BCA Assessment Report

2022 SCEGGS Wilkinson House

Reference No: 114039-BCA-r1

Date: 19 November 2021

DWG TITLE
DEMO WEST ELEVATION
DWG NO DA062 REV A

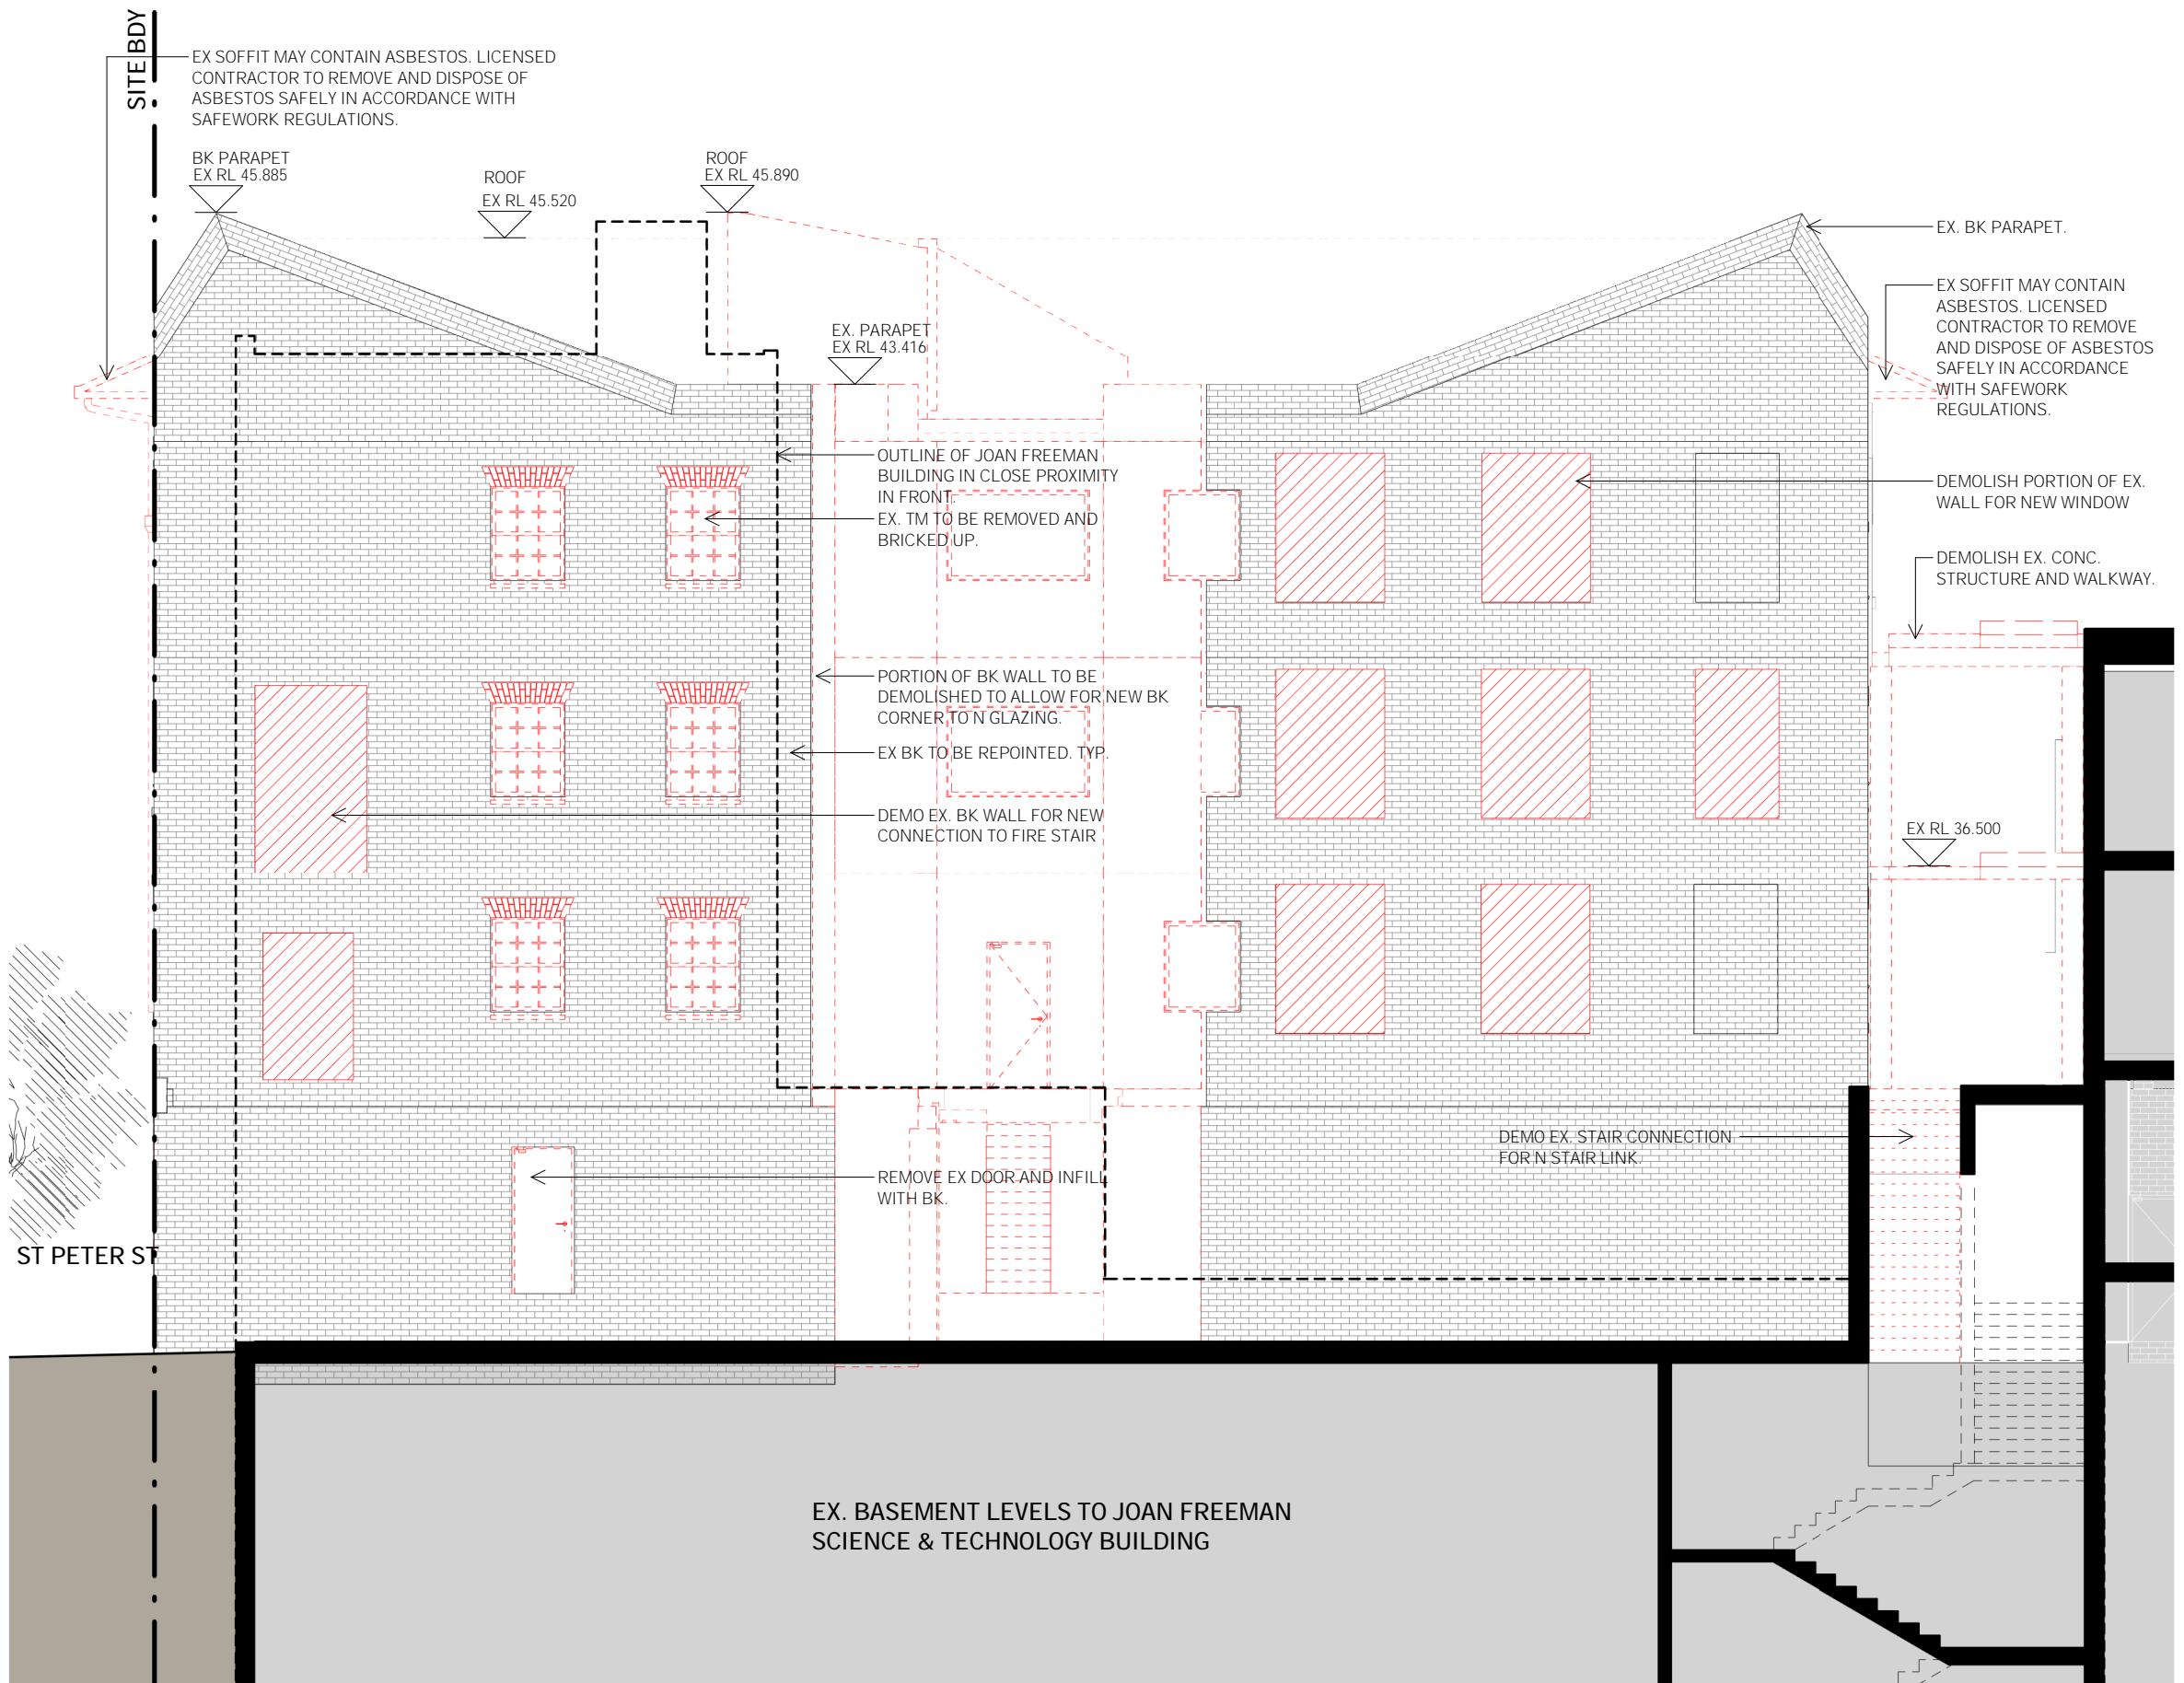
4.	The uniting of the re-built Wilkinson House building with the Joan Freeman building will require the western elevation with <u>existing windows</u> and new glass wall of the central stairway (refer to screenshot overleaf) to be considered an external wall exposed to an opposing external wall of other Joan Freeman compartment, less than 6m distant. Scaled at a separation distance of 3m, the subject Wilkinson House existing brick western wall is required to have a one hour' 60/60/60 FRL fire rating and the existing windows to be protected in accordance with BCA Clause C3.4, being: (a) external wall wetting sprinklers to permanently fixed shut windows/ or automatically closing windows; or (b) -/60/- FRL fire windows, permanently fixed shut or automatically closing; or (c) -/60/- FRL fire shutters; or	C3.3, C3.4 & 2.5 of Specification C1.1

Item	Description	BCA Provision
	<p>(d) <u>or a fire engineered performance based solution.</u></p> <p>Subject to the new glass wall of the central stairway being protected by external wall wetting sprinklers, Clause 2.5(d) of BCA Specification C1.1 permits the wall to <u>not</u> have a fire resistance level (a one hour fire resistance would otherwise be required by BCA C3.3 above). <u>However, note that this precludes the ability to have any openable windows or 'ventilators' unless they were to be fitted with automatic closing upon fire trip actuators.</u></p>
